## Appeal Decision

**Appeal Ref: APP/P1615/W/20/3244241**

**Land off Lansdown Road, Bream, Gloucestershire GL15 6NE**

- The appeal is made under section 78 of the Town and Country Planning Act 1990 against a refusal to grant planning permission.
  - The appeal is made by Mrs Joan Davis against the decision of Forest of Dean District Council.
  - The application Ref P0693/19/FUL, dated 12 April 2019, was refused by notice dated 10 May 2019.
  - The development proposed is to erect a detached dwelling with amended access.
-

Drawing No:
20/19/01

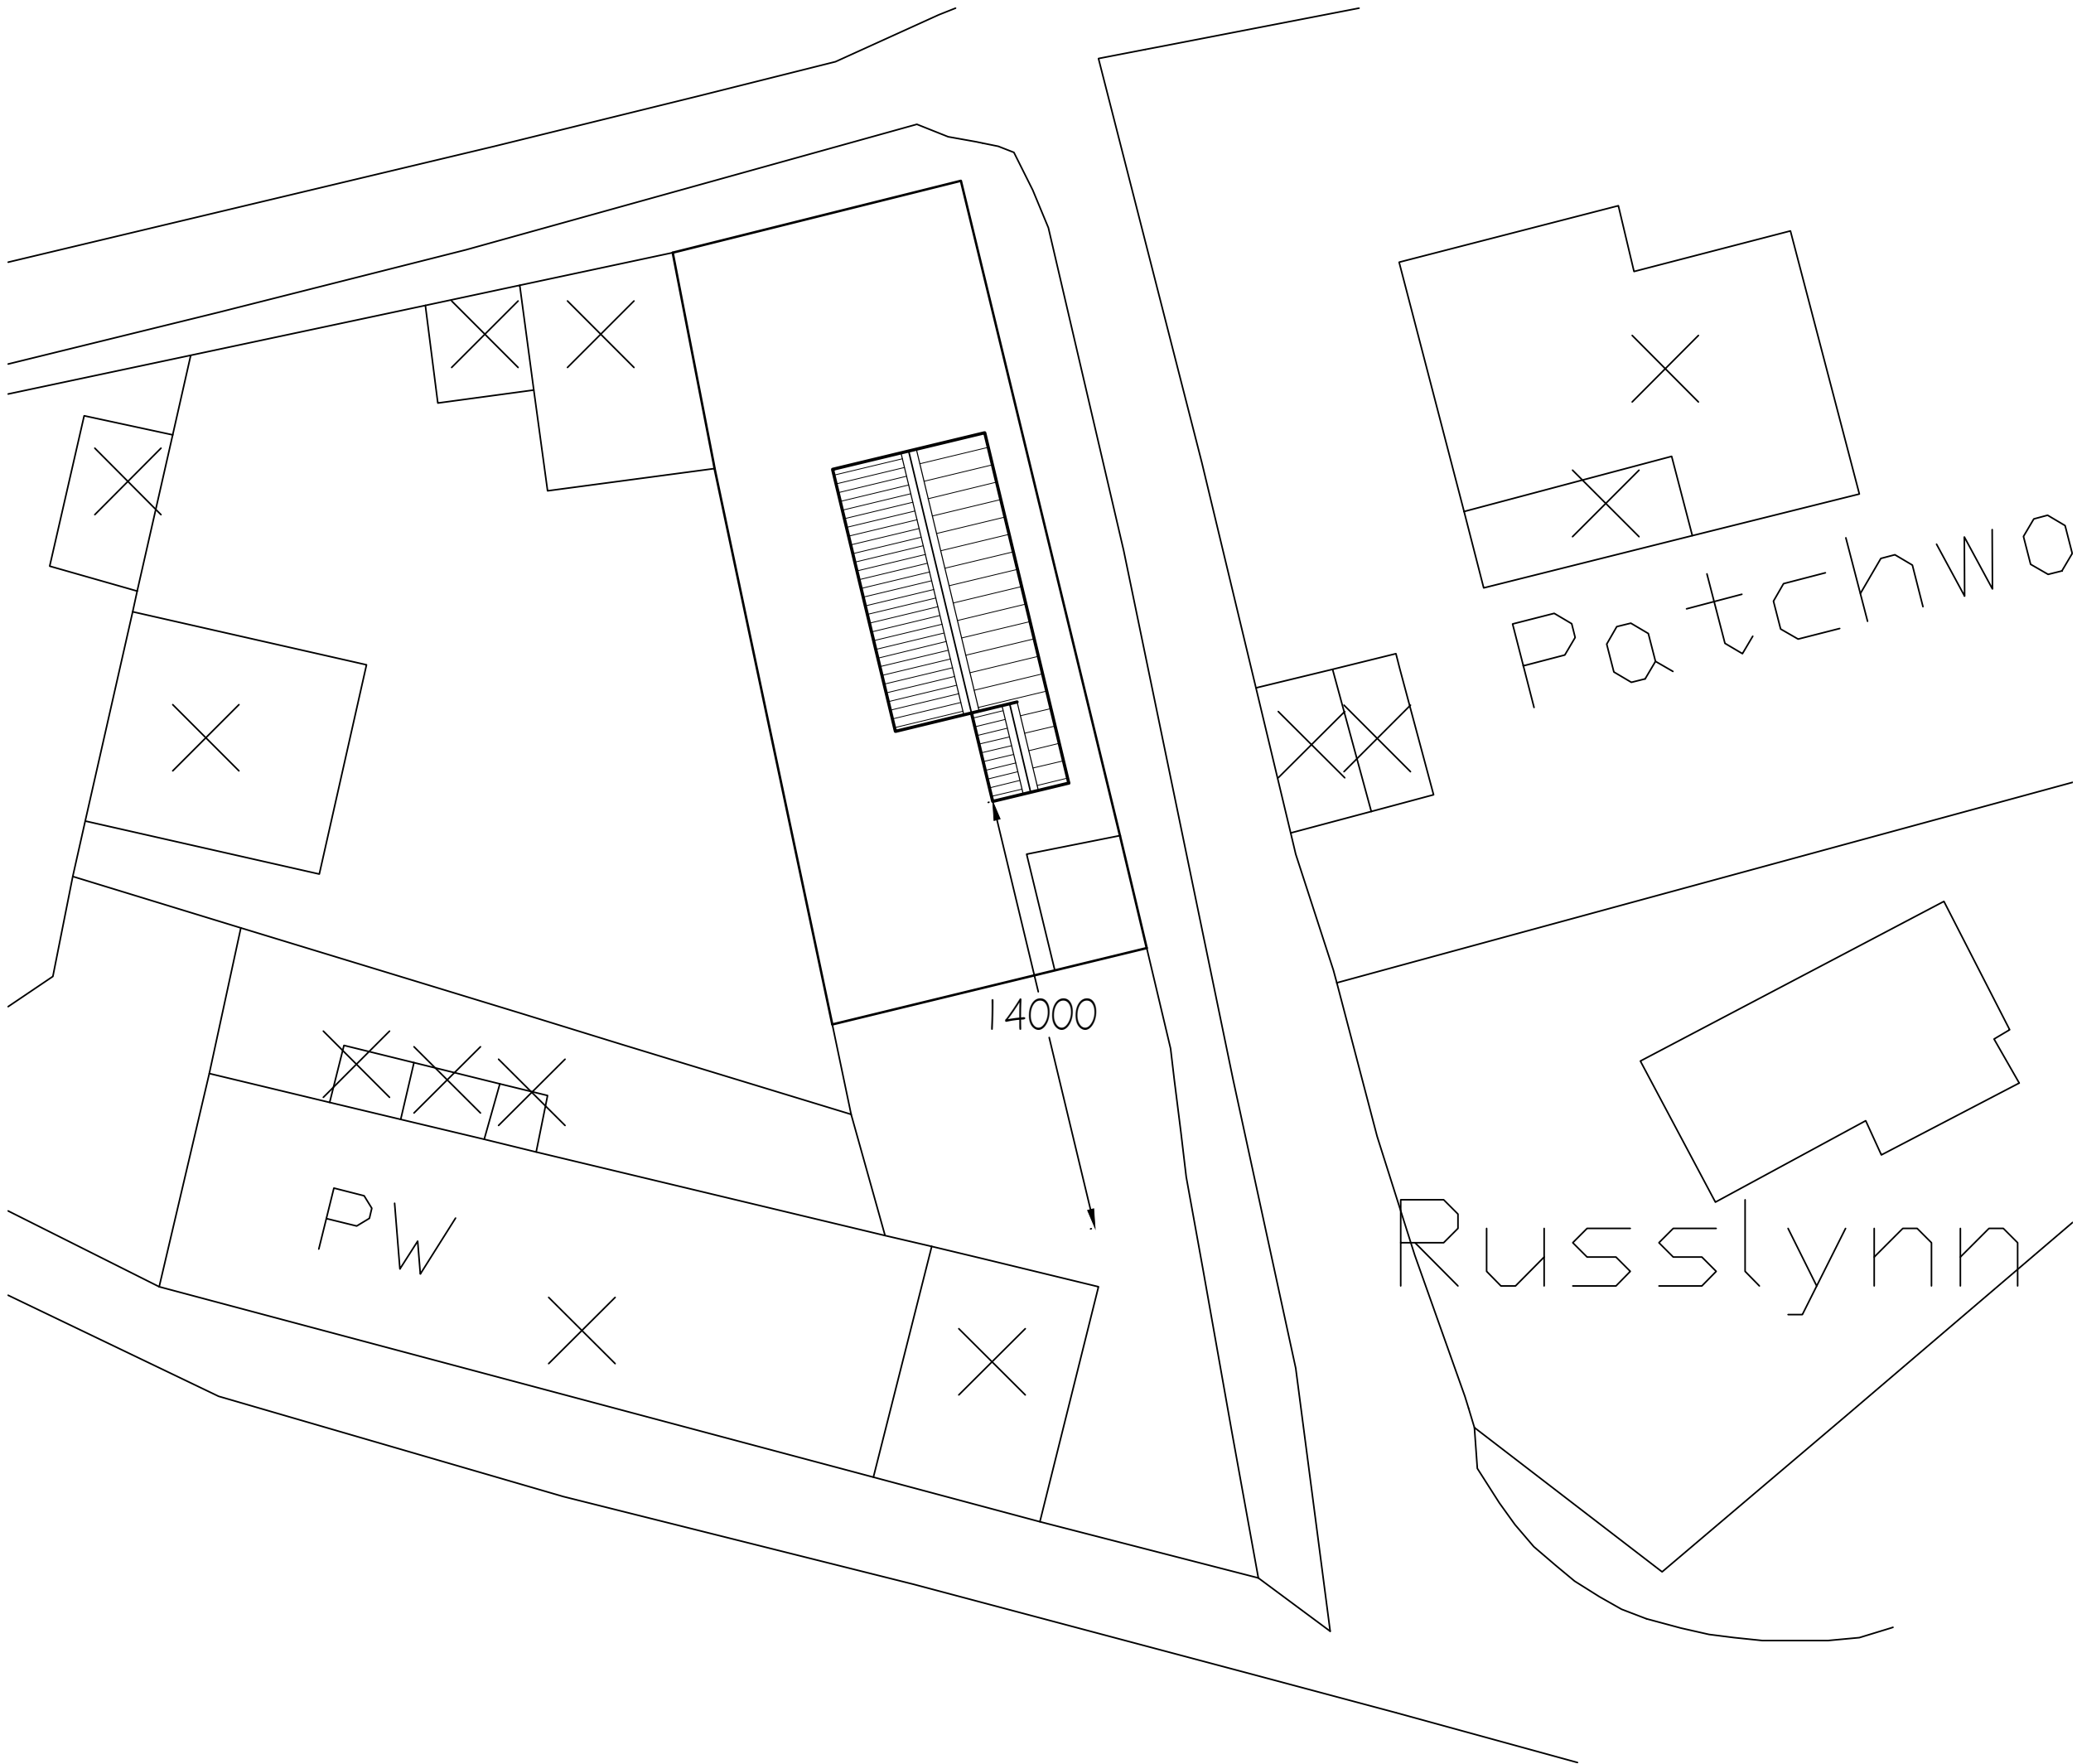
15. Within the site, a parking space and turning area is shown on the submitted plans. I also note that if necessary it may be possible to accommodate a second parking space, but considering the size of the dwelling in an accessible location, I have no concerns over the parking provision.

16. The proposed drawings show a vision splay based from different set back positions. The appellant states that at a 2.4m setback 15m splays can be achieved, and at a 2m setback 16m is achievable. I understand that 2.4m is a common position set back from the carriageway edge to work out the possible vision splay, but the appellant states that Manual for Streets 2 allows for this to be reduced to 2m off quiet roads. From the evidence before me and my own observations, Lansdown Walk is lightly trafficked with low speeds common.

17. If the 2m setback was to be used, a distance of 15m may be sufficient. However, I note from the County Highway comments that although they have not objected, a condition requiring the 15m splays would be necessary and should be to the nearer carriageway edge. The submitted plan shows the splay to the left linking with the centre line of the carriageway, whilst to the right it is set 1m from the carriageway edge.

18. In terms of the view to the left (west) along Lansdown Walk, I understand that as vehicles approaching from the west would be on the left hand-side of the road. However, to achieve this the line of sight the vision splay appears very close to the front wall of the neighbouring property at Rowan House. On this matter, the appellant states that the driver of a vehicle leaving the appeal site would be able to see over and past the 0.8 m high stone wall that fronts Rowan House. It is true that currently this is a low stone wall, but the appellant, from the evidence before me, does not have control over this land and so this could change, either by a taller structure being built or new high planting. This would obscure some of the vision, which could be critical.

19. For the view to the right (east), I understand that Manual for Streets 2 does state that often vehicles drive in from the kerb line and therefore a more accurate assessment of the vision splay is made by measuring the nearside of the vehicle track. The appellant suggests that the County Highway Officers support a distance of between 0.5m and 1m out from the verge to calculate the vision splay possible. Due to the narrowness of this stretch of Lansdown Walk I accept that most vehicles would be quite central in their road position, but there is insufficient detail of how a distance of between 0.5m and 1m out from the verge has been decided as suitable in this particular circumstance.

20. Furthermore, the submitted plan BG001 has used the 1m distance from the carriageway edge, rather than the 0.5m. There is insufficient information to explain why 1m should be used to demonstrate the vision splay rather than the 0.5m, as this could make a crucial difference in this setting. It is stated by the appellant that using the 0.5m out from the verge the vision splay could still be sufficiently achieved, but there is insufficient detail to demonstrate this.

21. Further to this, if the figure of 1m outset from the verge is used, although this would account for most wider vehicles, such as cars and vans, there is also the

safety of cyclists, for example, who may not be positioned so centrally in the road and therefore may not be so apparent in the vision splay as proposed.
